TRAILS AT ASPEN RIDGE FILING NO. 2

FINAL GRADING & EROSION CONTROL PLANS

NOVEMBER, 2019

ROADWAY PLAN & PROFILE

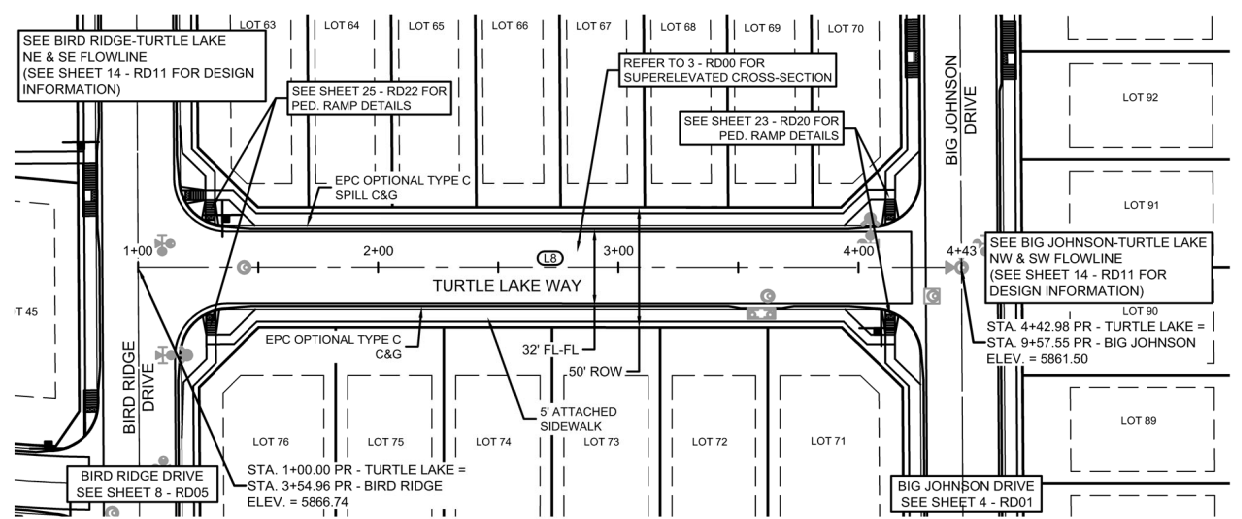
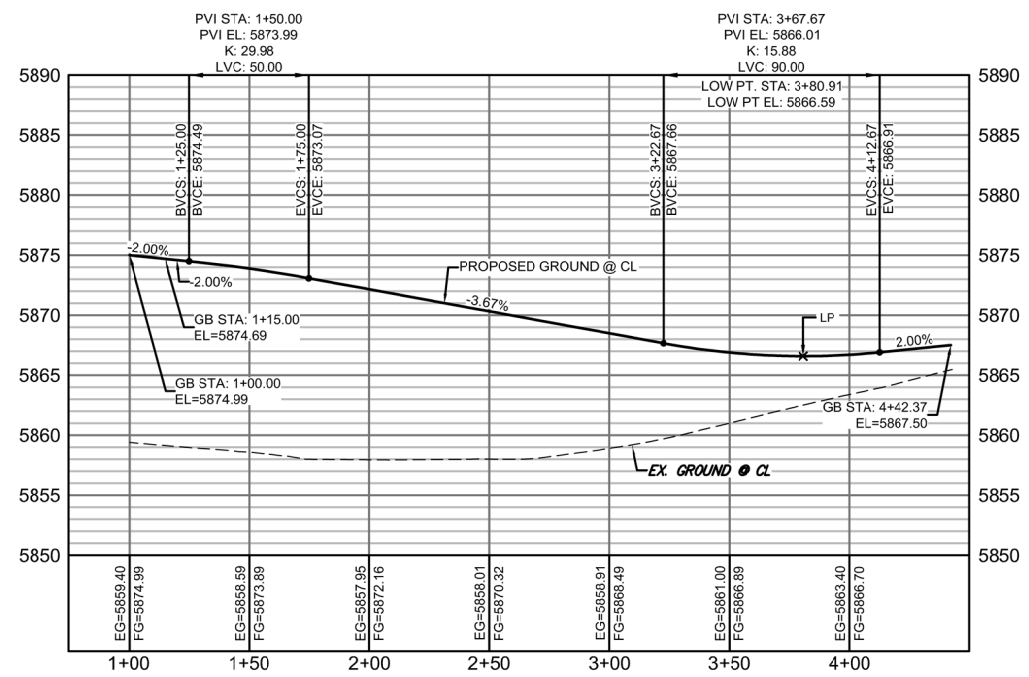
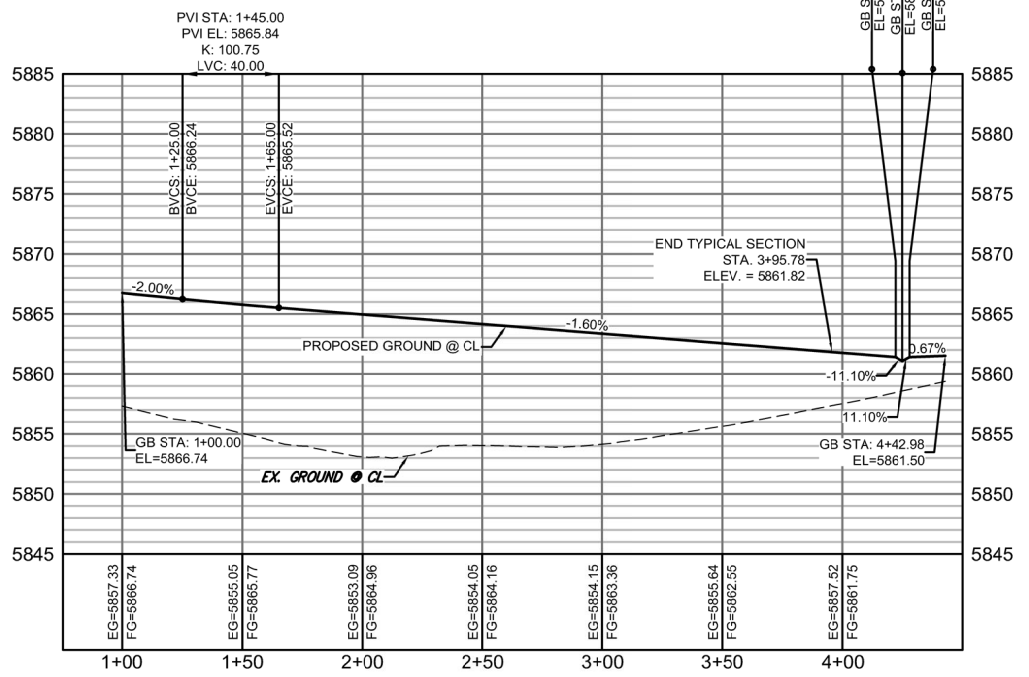
Superelevation is not permitted for design speeds less than 50 mph. Revise or submit a deviation request.

A Deviation Request has been provided with this submittal for Nutterbutter Point and Turtle Lake Way. Per Matrix conversation with Gilbert, Moose Meadow and Roundhouse are considered warped intersections rather than superelevated streets.
